Orsted Hornsea Project Four Limited
Development Consent Order (DCO) Application for Hornsea Project Four
Offshore Windfarm
Application Reference: EN010098

Response to Request for Information

Our ref. EN010098

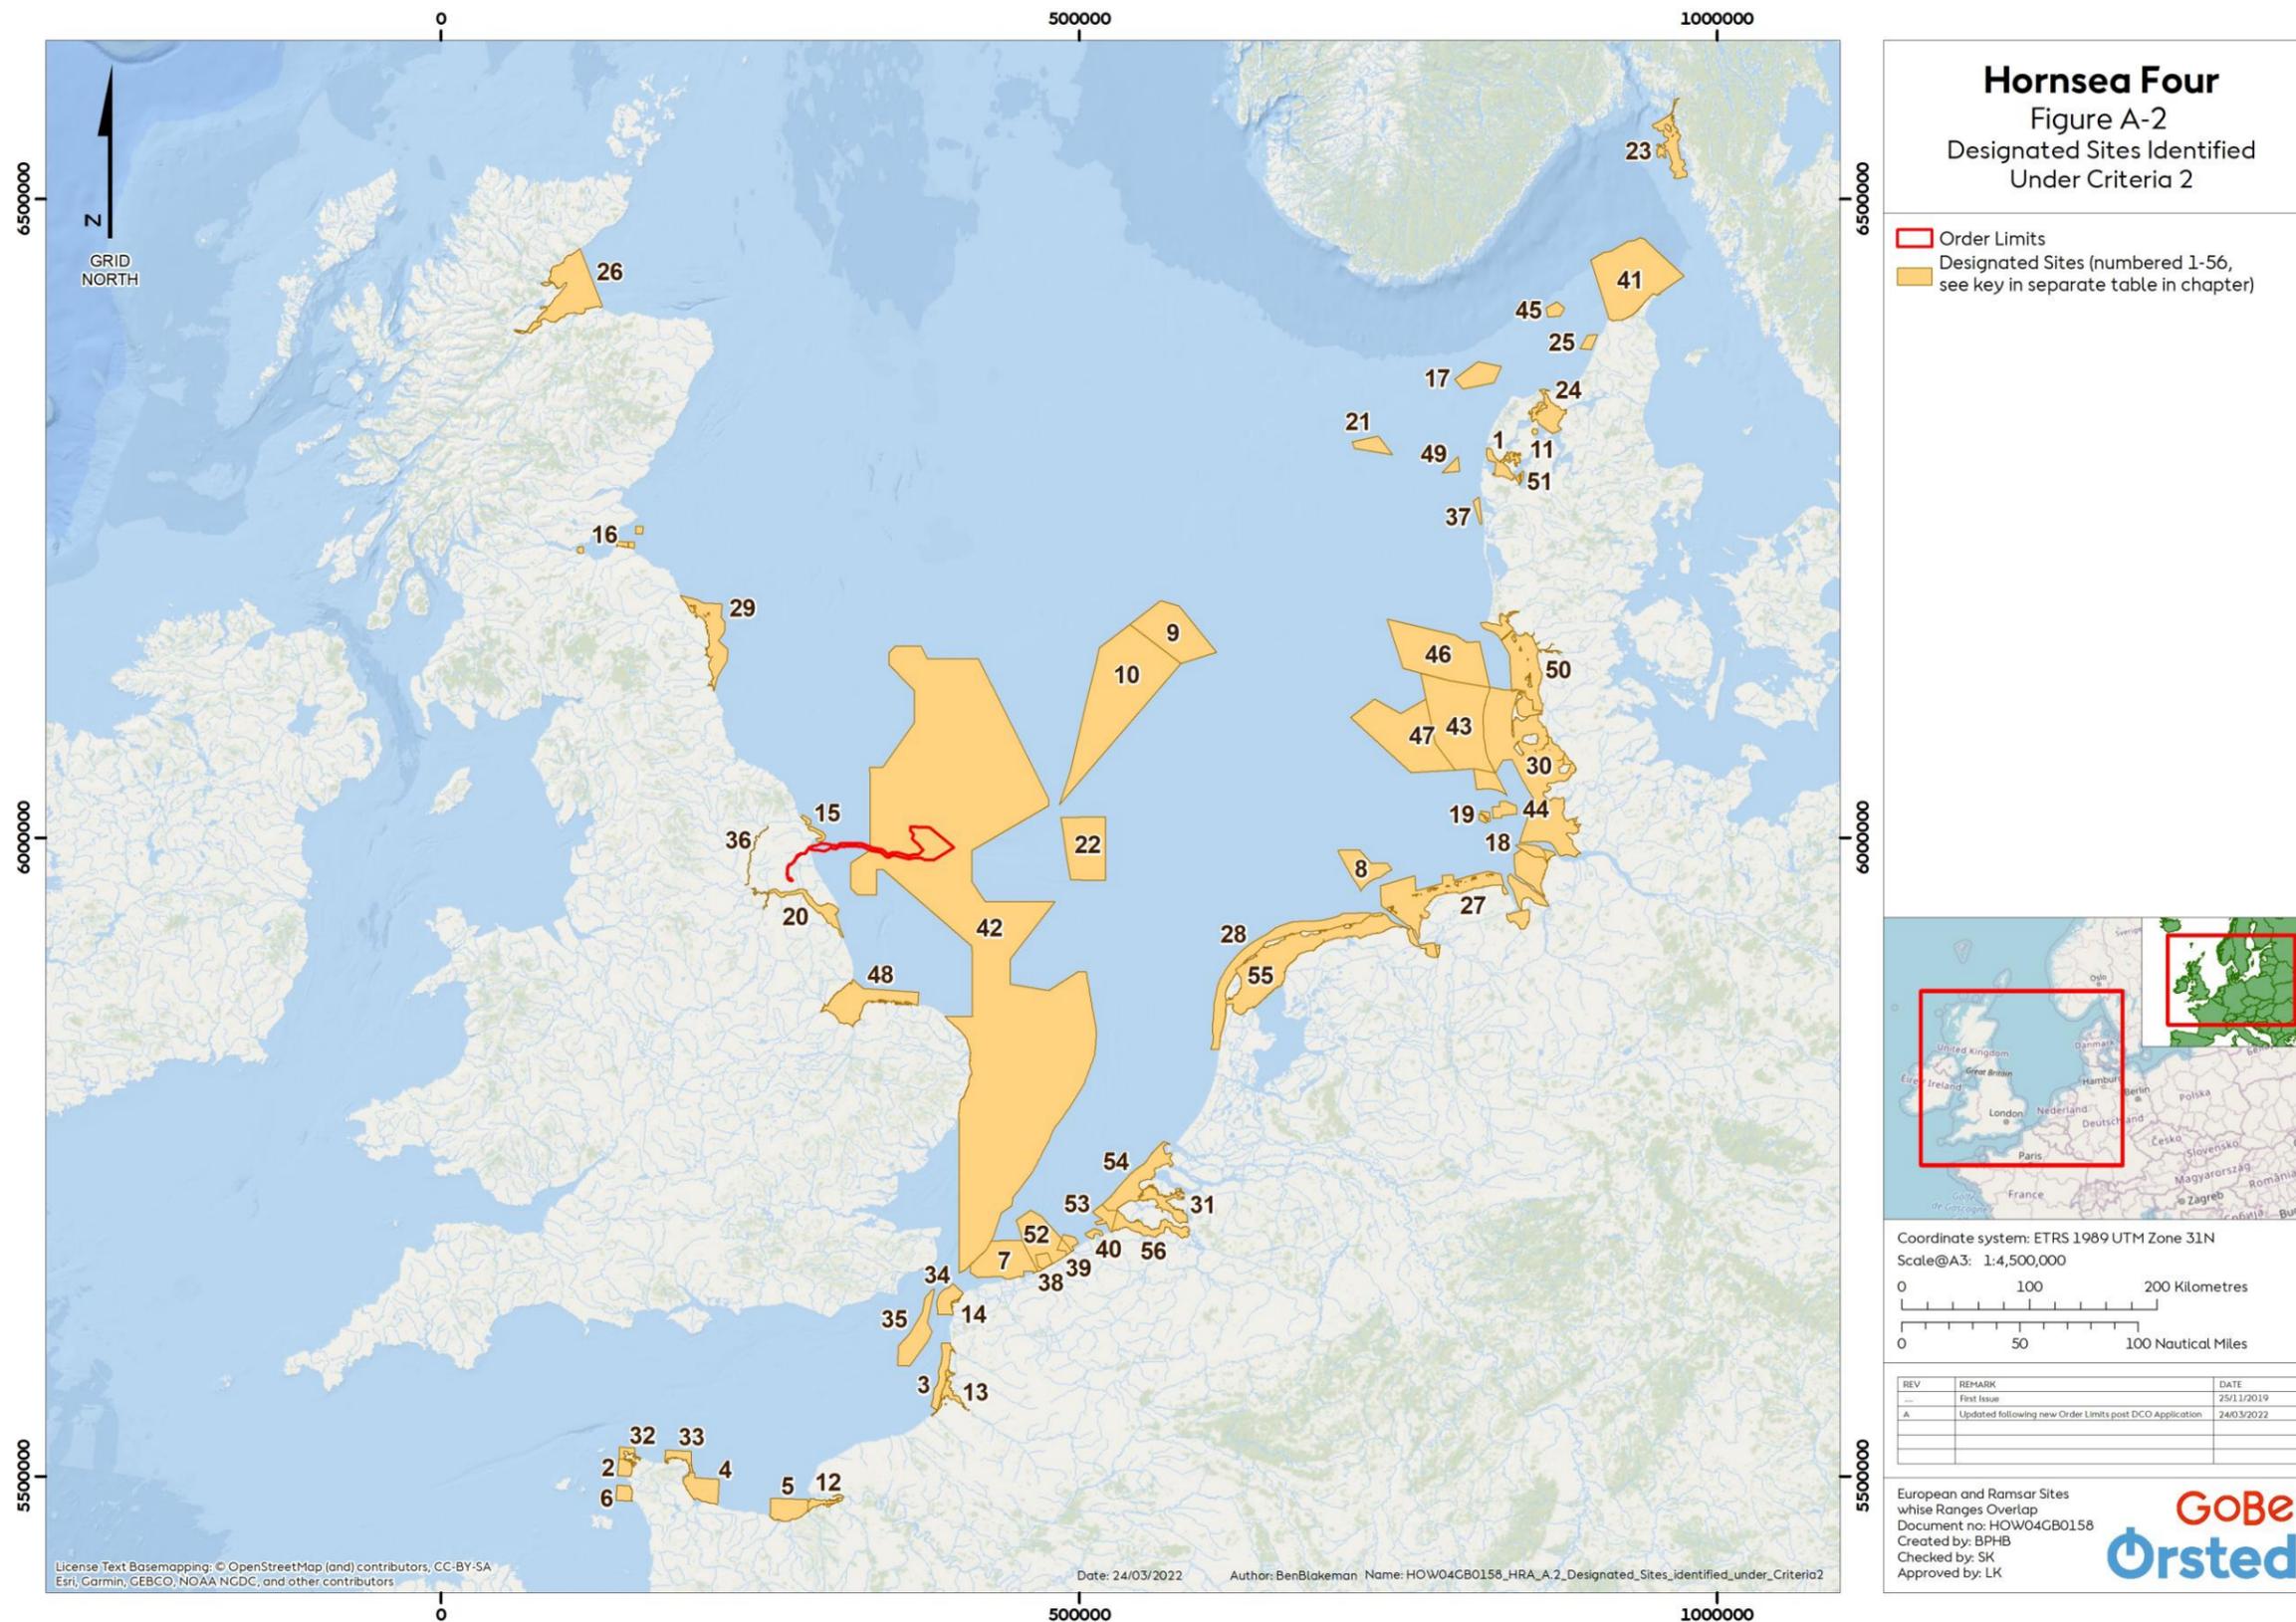
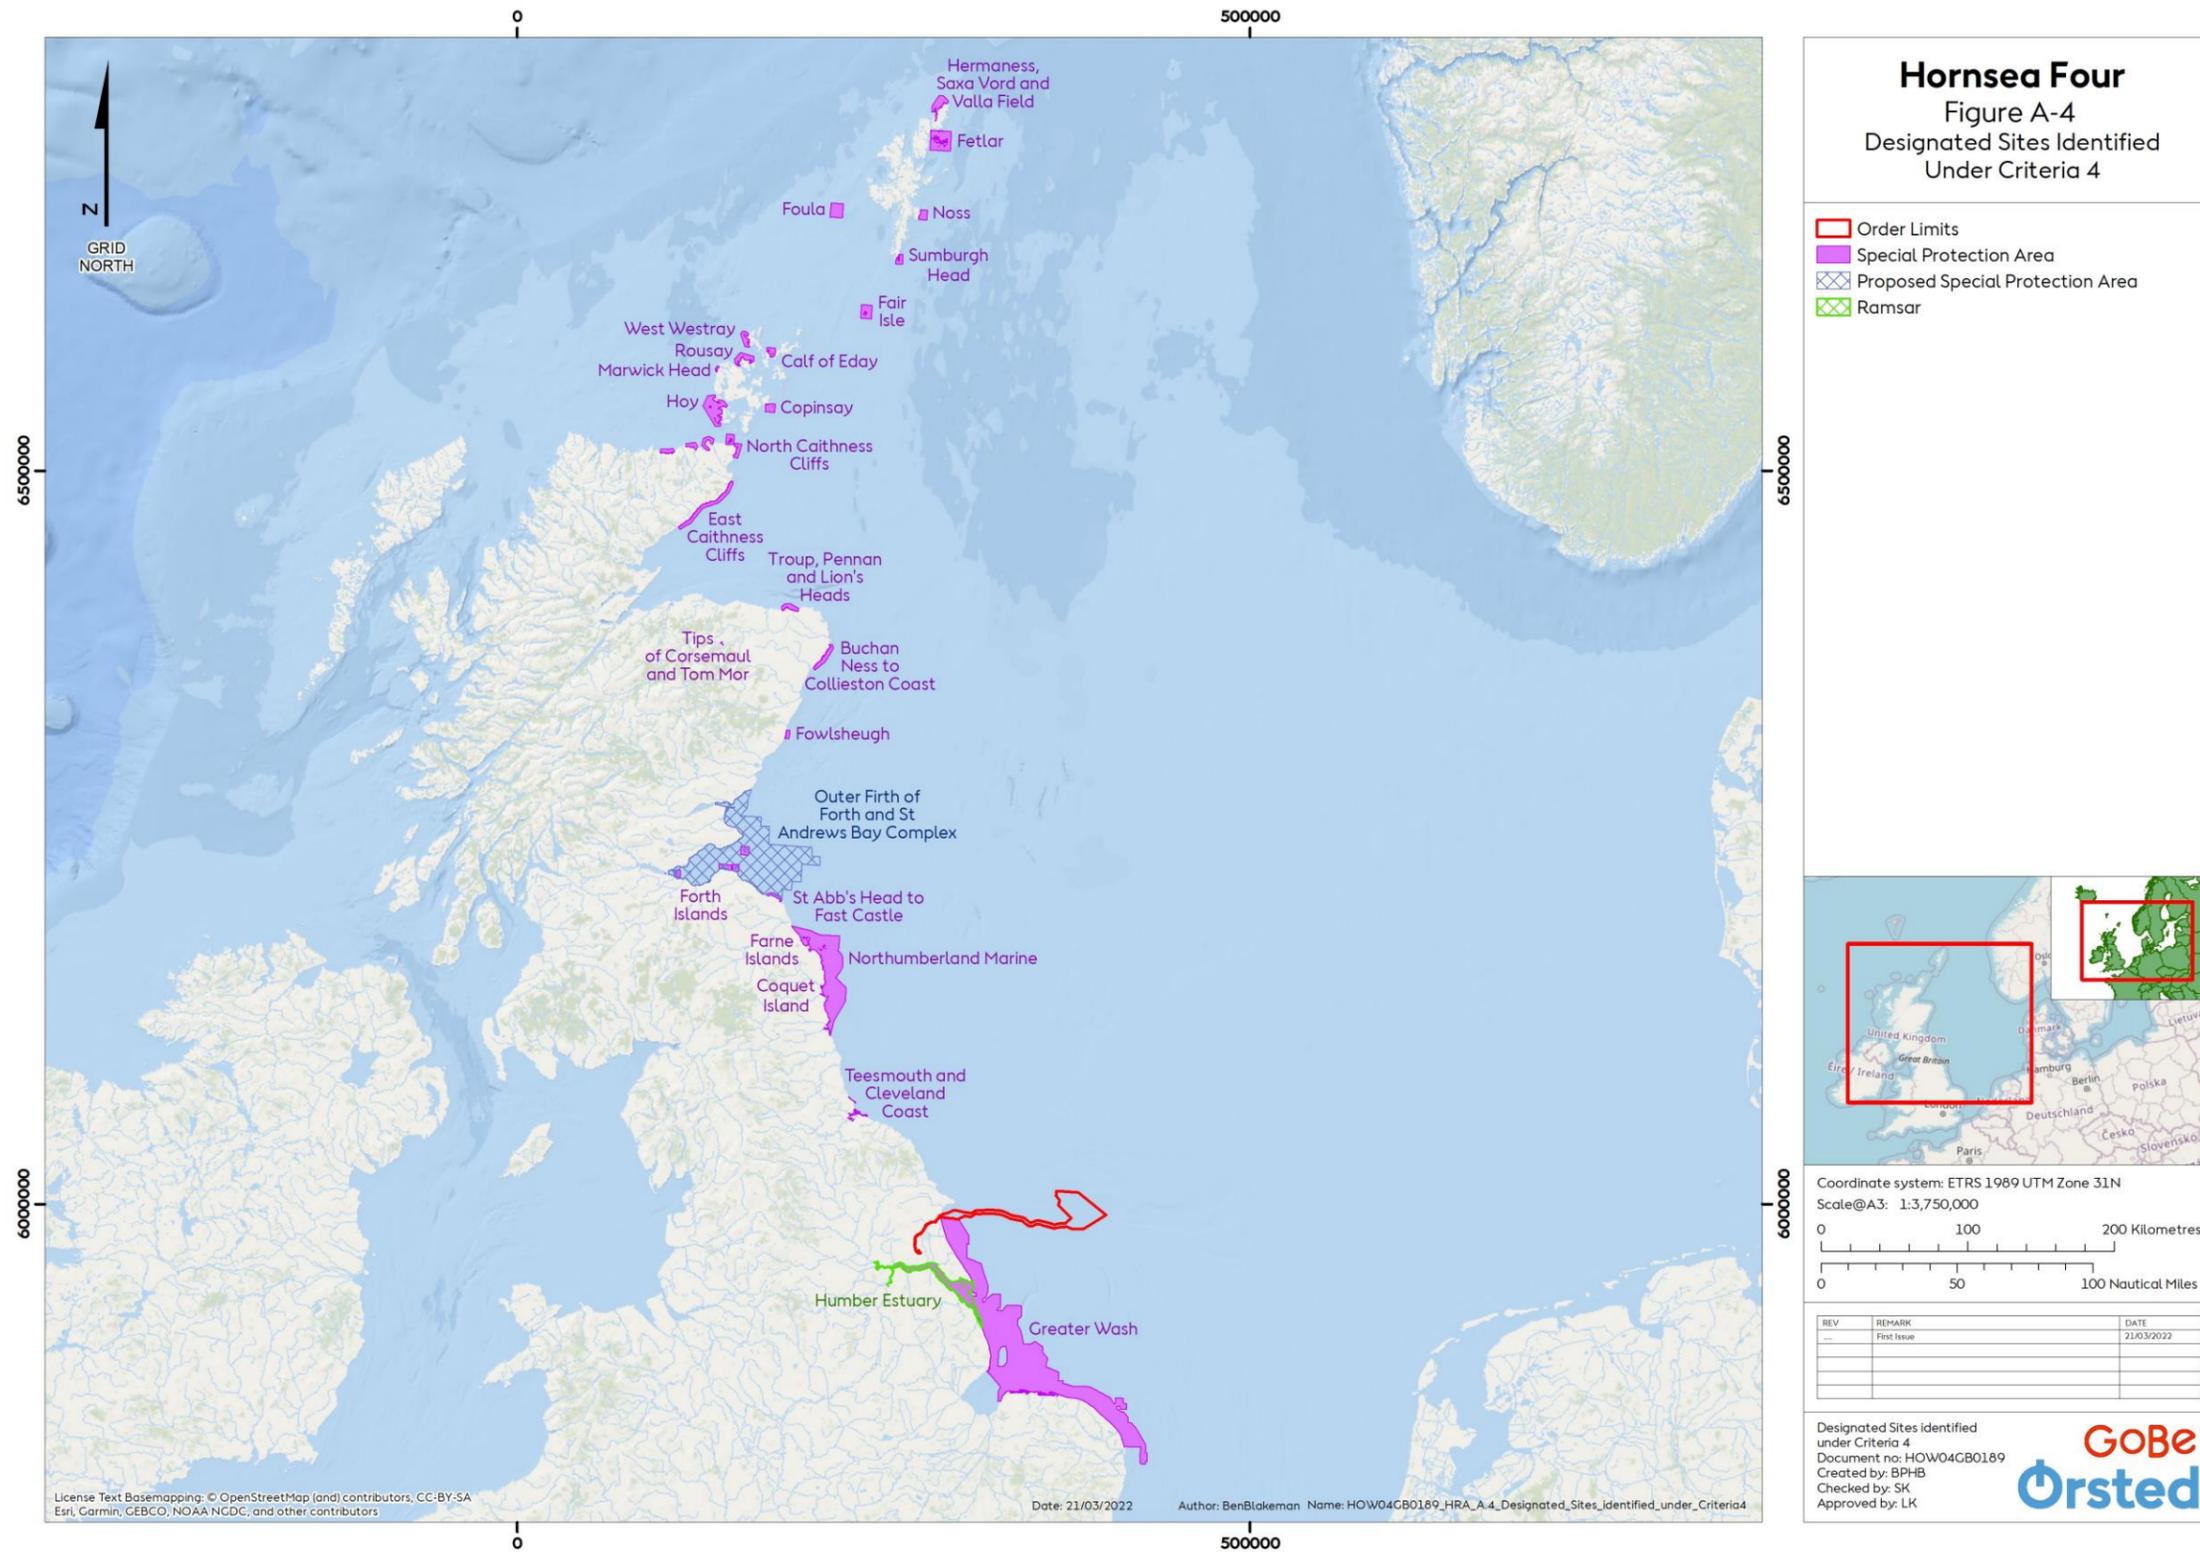
13. Please refer to [B2.2 Report to Inform Appropriate Assessment Part 2](#) (a clean and tracked version) submitted alongside this letter. The SoS should note one additional correction to Figure A2 and A4 which is the removal of the Northumberland Marine SPA. This was originally included in error as Natural England confirmed that the HRA screening assessed the relevant SPAs (Farne Islands and Coquet Island) separately and they considered that it was not necessary to also assess the Northumberland Marine SPA. The SoS is referred to page 28 of [APP-168](#).
